DRB CASE ACTION LOG

DRB Application No.: 04DRB-00380 (P&F) Project # 1003308
Project Name: FAIRGROUNDS ADDITION
Agent: Fred French PAT DOMINGUEZ Phone No.: 268-4361 off
(980 9493 cell.)

Subdivision Name: Fairgrounds Addition - Lot 3A, Block 10

**PLAT OF LOT 3-A**  
 BLOCK 10  
 FAIRGROUNDS ADDITION  
 CITY OF ALBUQUERQUE, NEW MEXICO  
 MARCH 2004

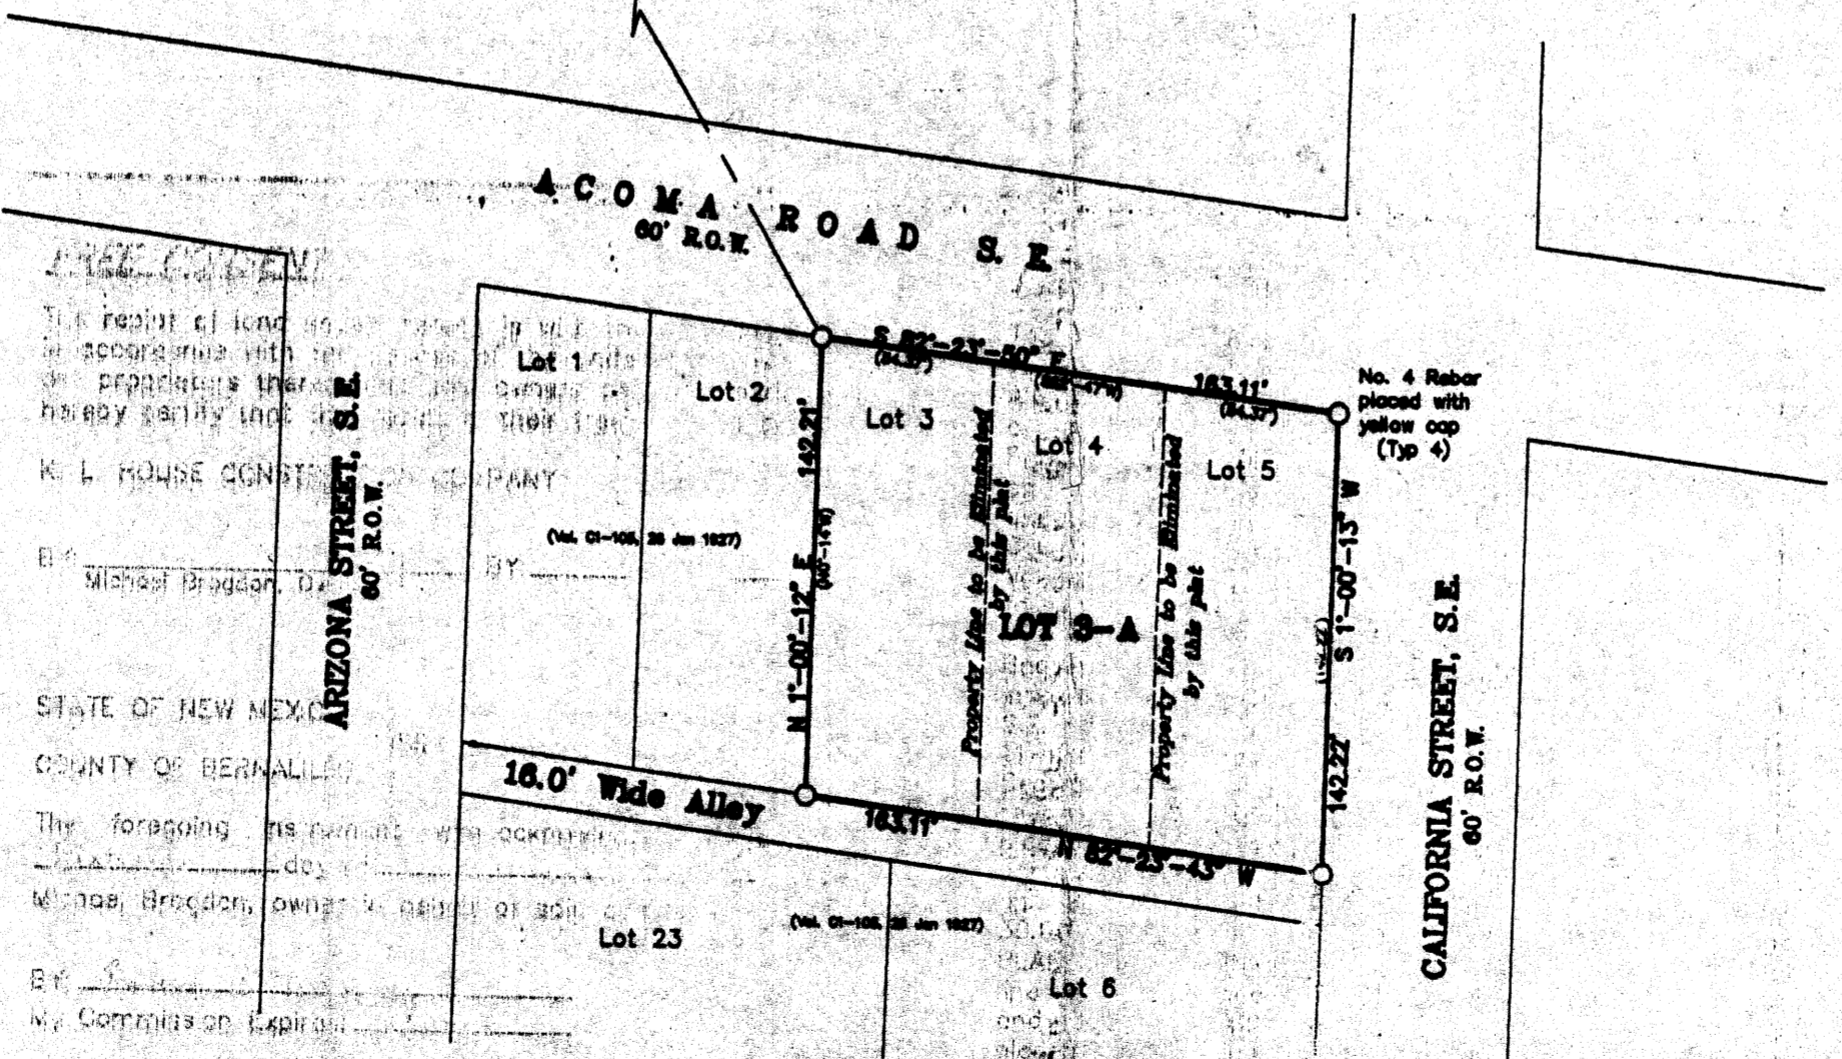
- TRANSPORTATION: ① DEDICATION of 20' radius @ corner sk
- _____ ch
- ② Need New ARIS DXF APPROVAL
- _____ g/A
- _____ S-404
- UTILITIES: _____
- _____
- _____
- _____
- CITY ENGINEER / AMAFCA: _____
- _____
- _____
- _____
- PARKS / CIP: _____
- _____
- _____
- _____
- PLANNING (Last to sign): _____
- _____
- _____
- _____
